Response to Submission comments for Redevelopment of Greenwich Hospital (Concept) (SSD 8699)

Thank you for your referral dated 22 October 2019 inviting comments from the Heritage Council of NSW on the above State Significant Development (SSD) Response to Submissions for the redevelopment of Greenwich Hospital including: a new health care and allied health facilities, residential aged care and seniors housing in an integrated care campus including building envelopes, car parking and site access arrangements.

Cheryl Brown
Manager, Northern Region
Heritage NSW
Department of Premier and Cabinet
As Delegate of the Heritage Council of NSW
15 November 2019

DATE: AUGUST 2019	DRAWN: ML, JC	PROJ ARCH: BF	SCALE: 1:500 @ A1
	PROJ: 1213	DRAWING: S.02	REVISION: P5

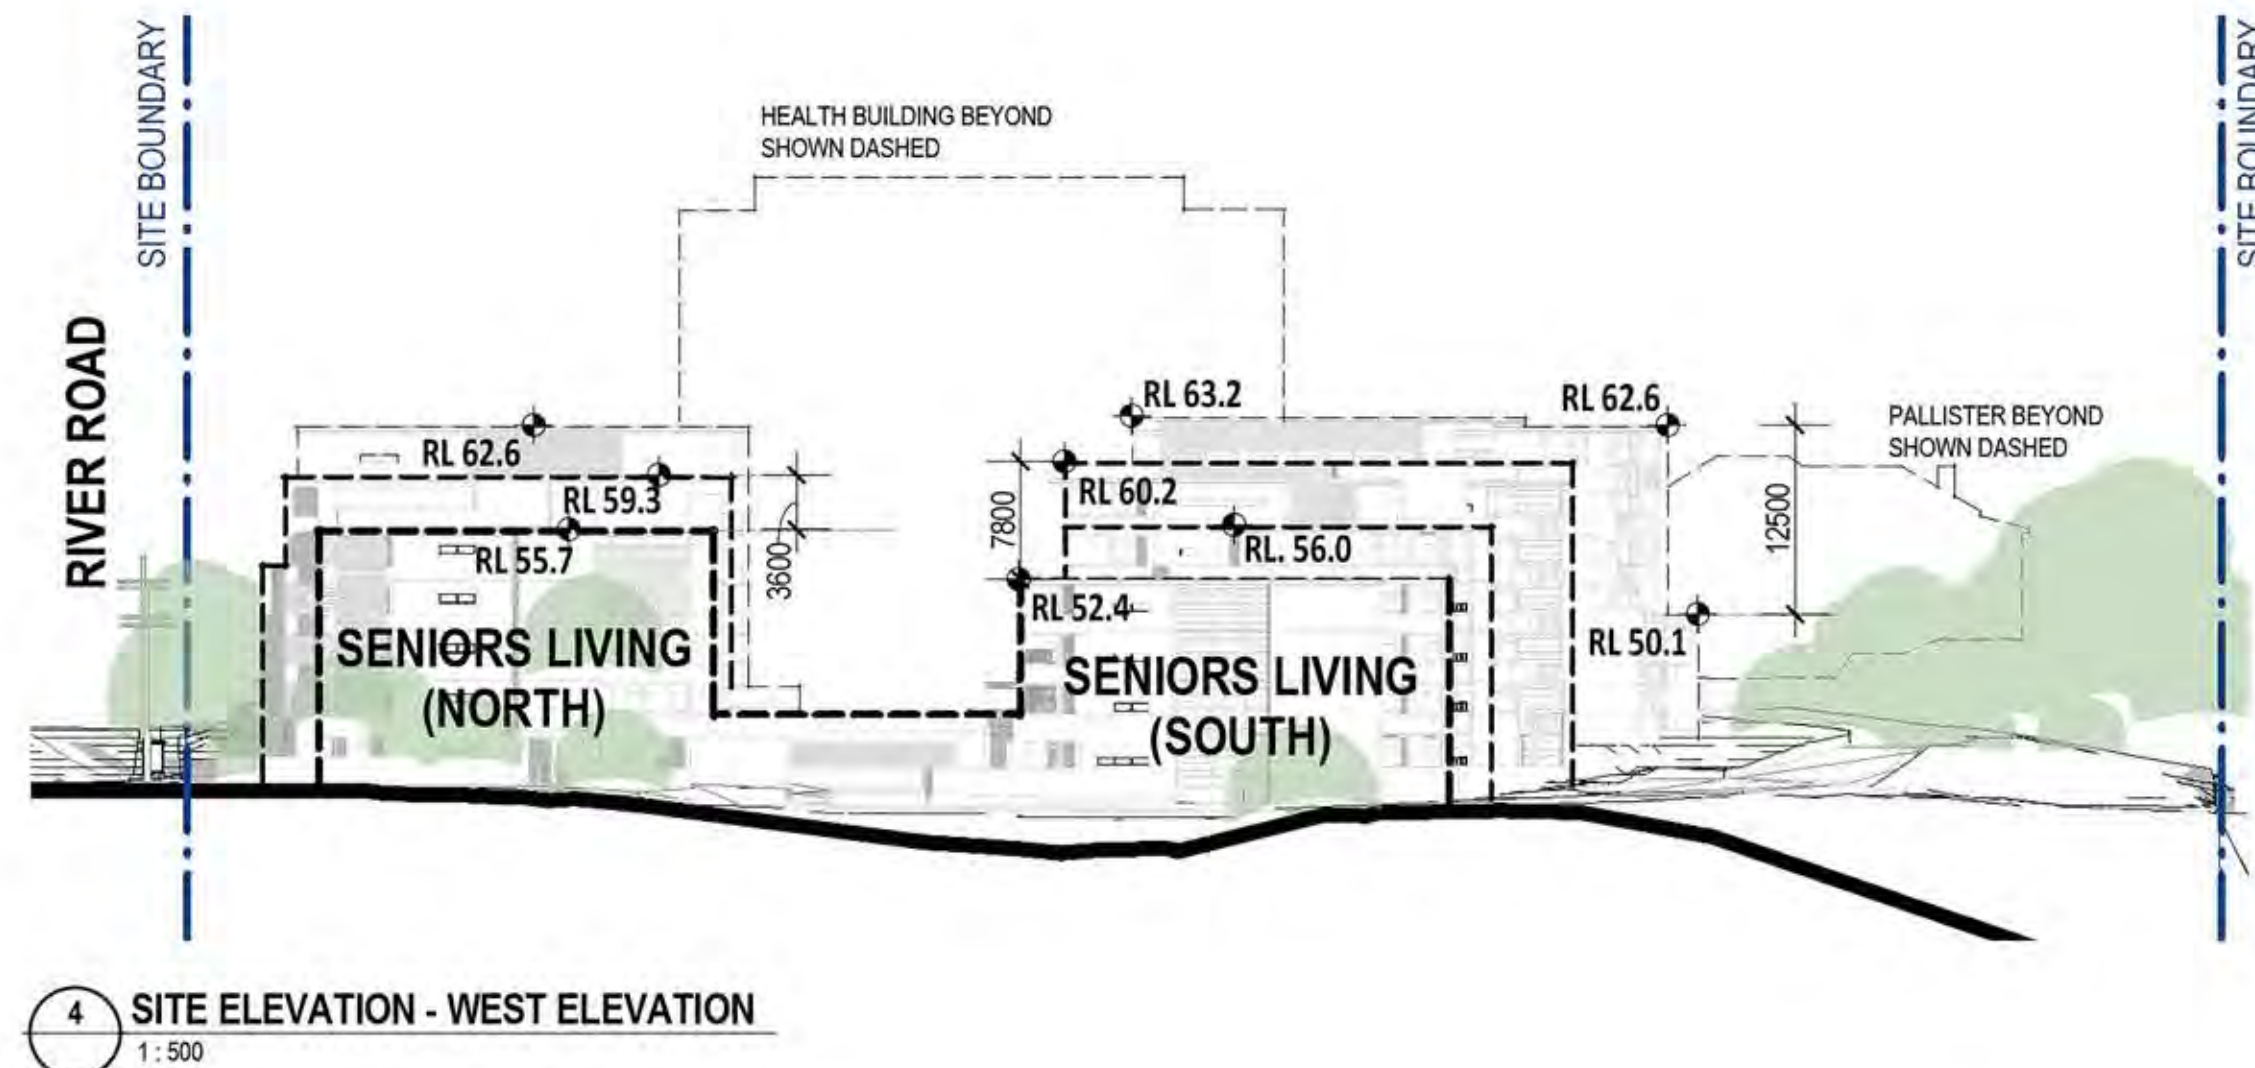
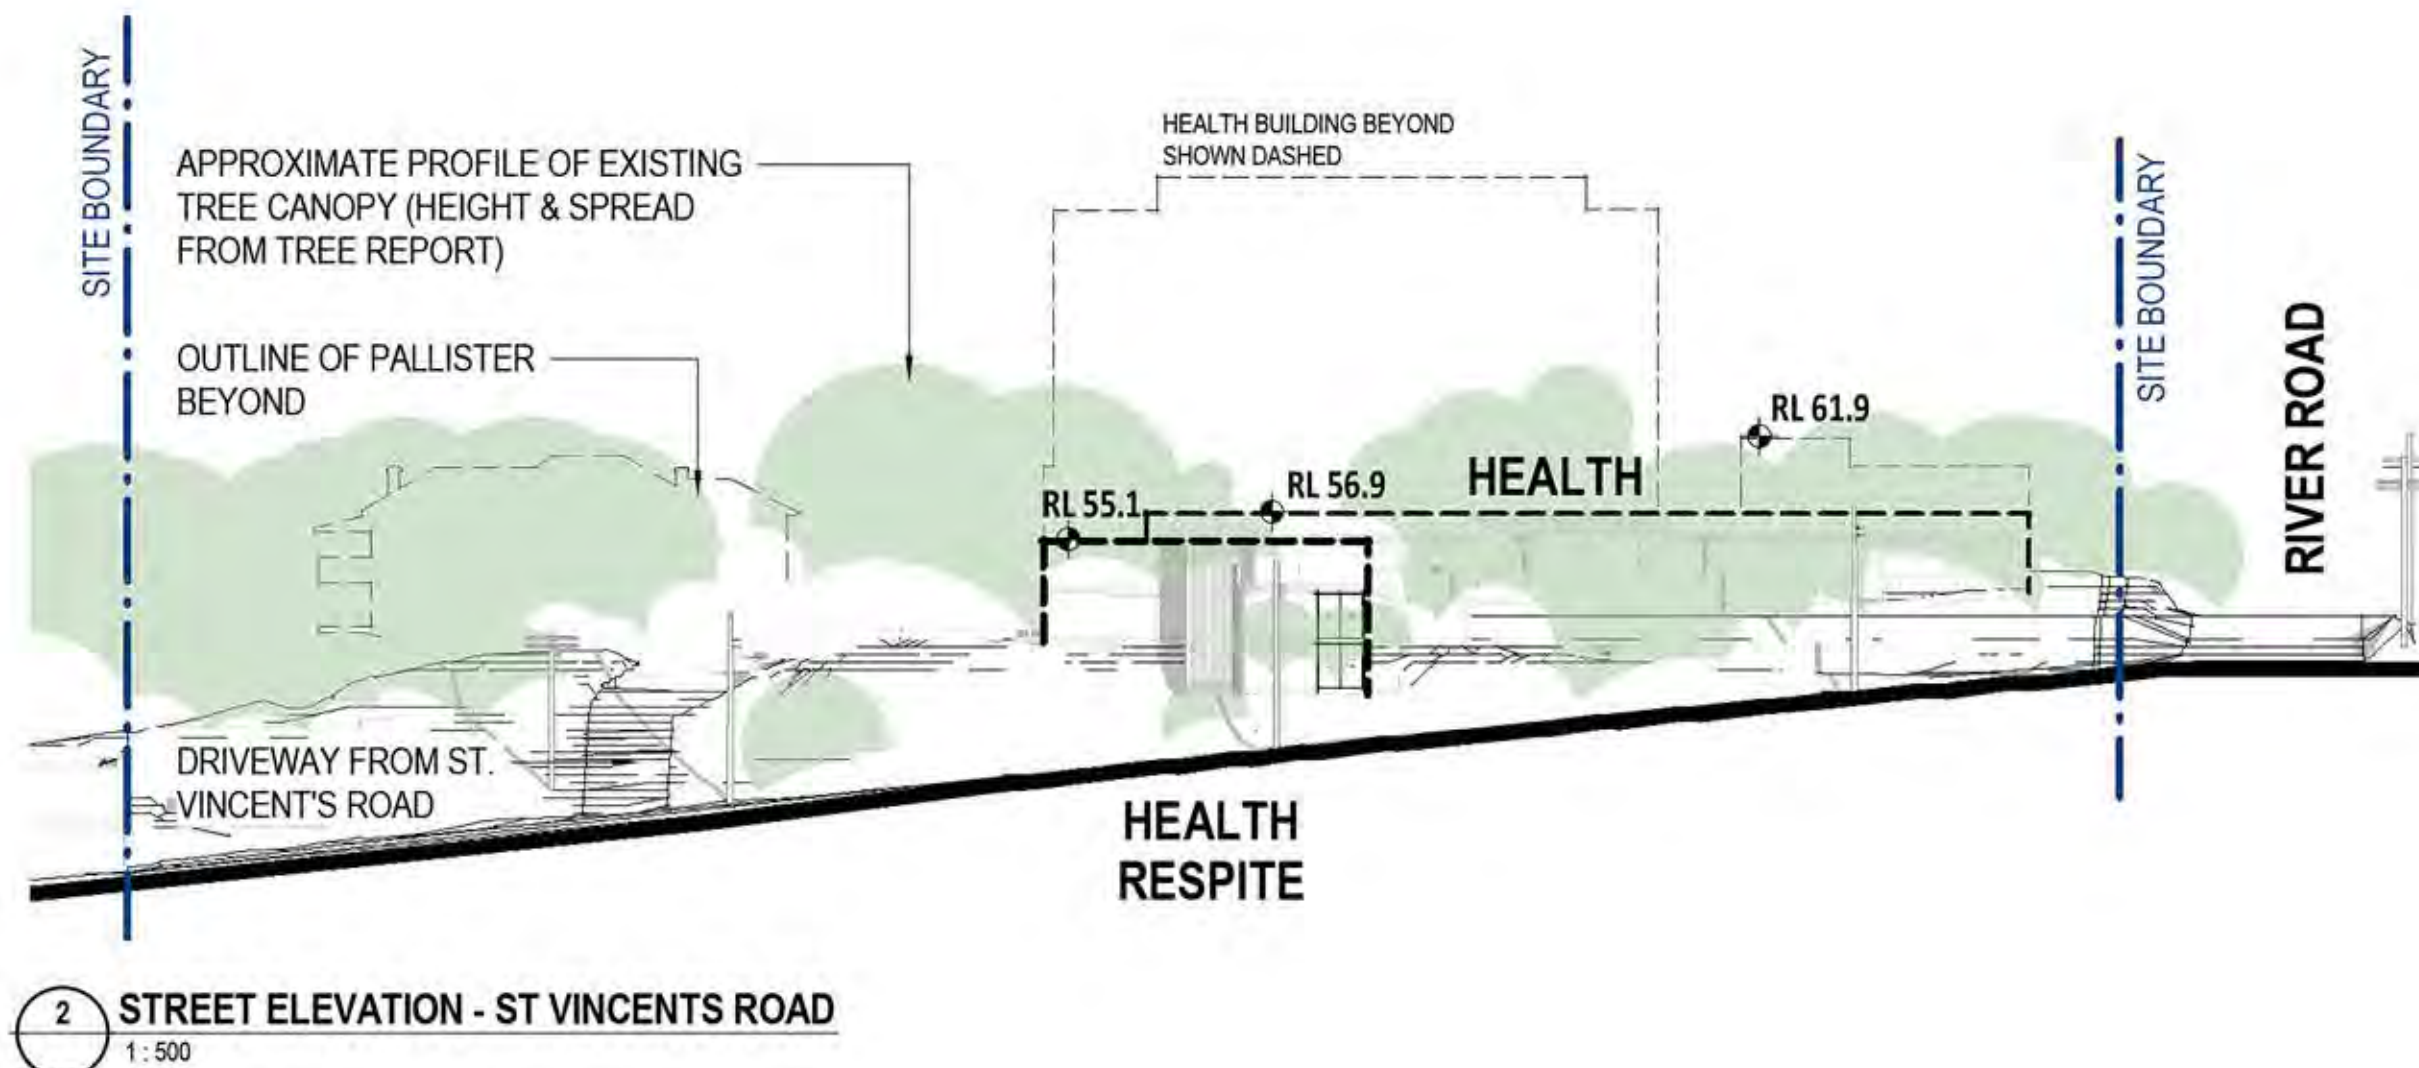
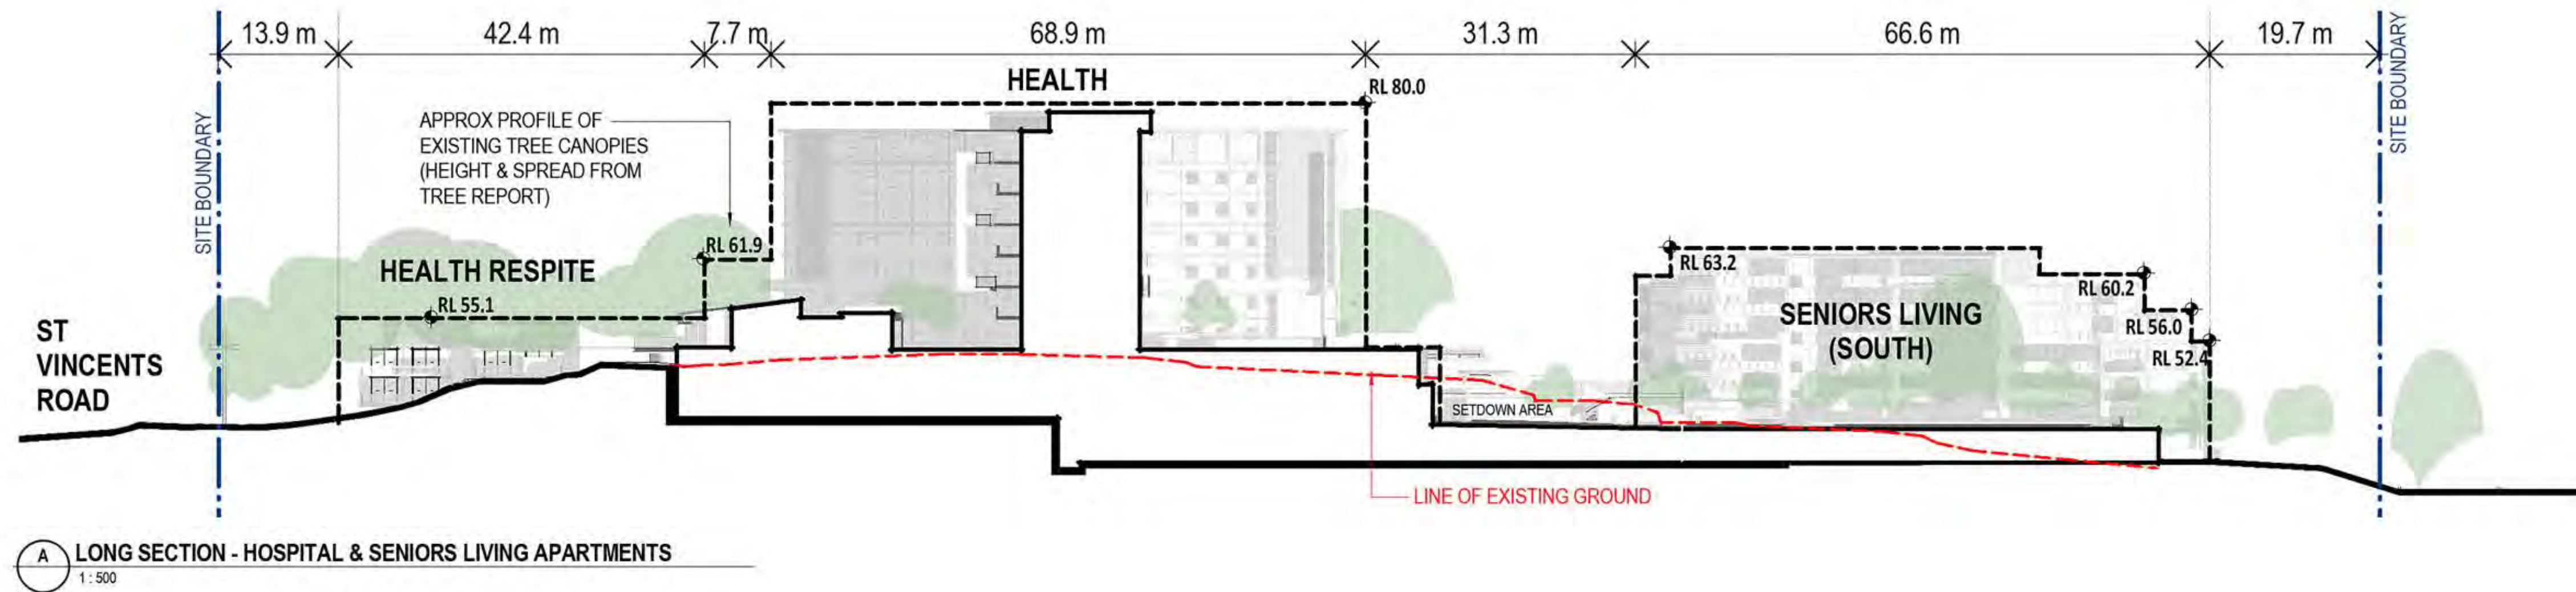
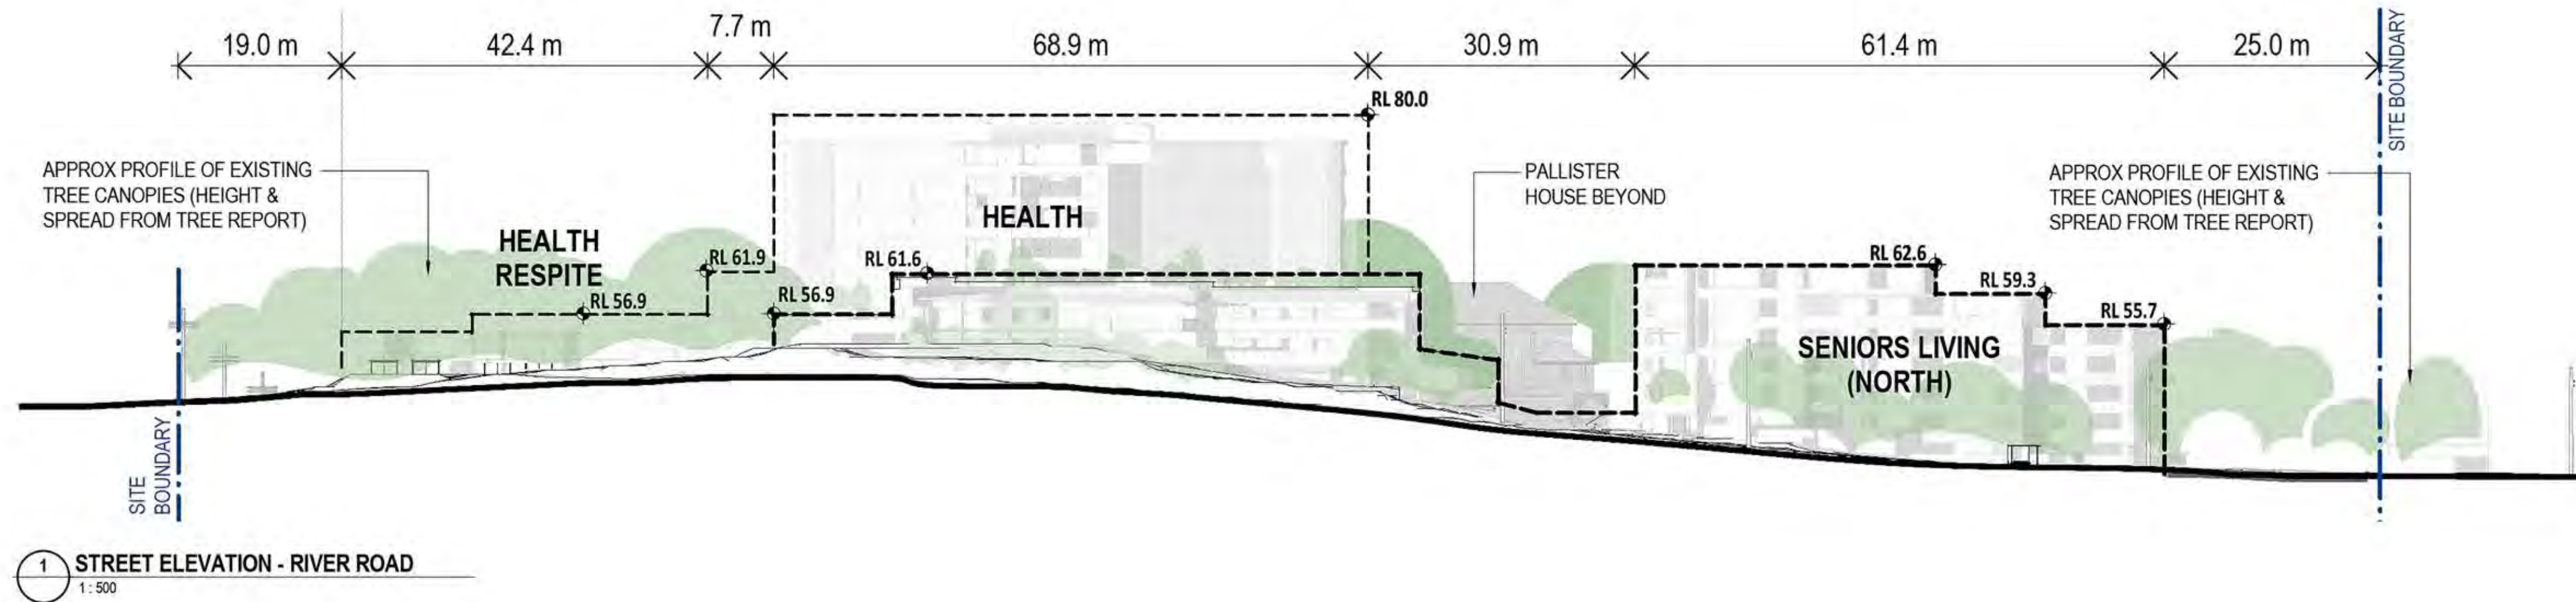
- g) In addition, comments provided during the site visit by Heritage NSW staff outlined that the high-level link bridge between the Hospital and Respite Centre should be removed to minimise impacts on the heritage setting of Pallister. The link bridge still appears on several plans (e.g. Drawing S.02) but not on others in the Set of Approval Drawings (Appendix A). This bridge should be removed from all plans and drawings to the site to make it clear that its construction is not part of the proposed works.
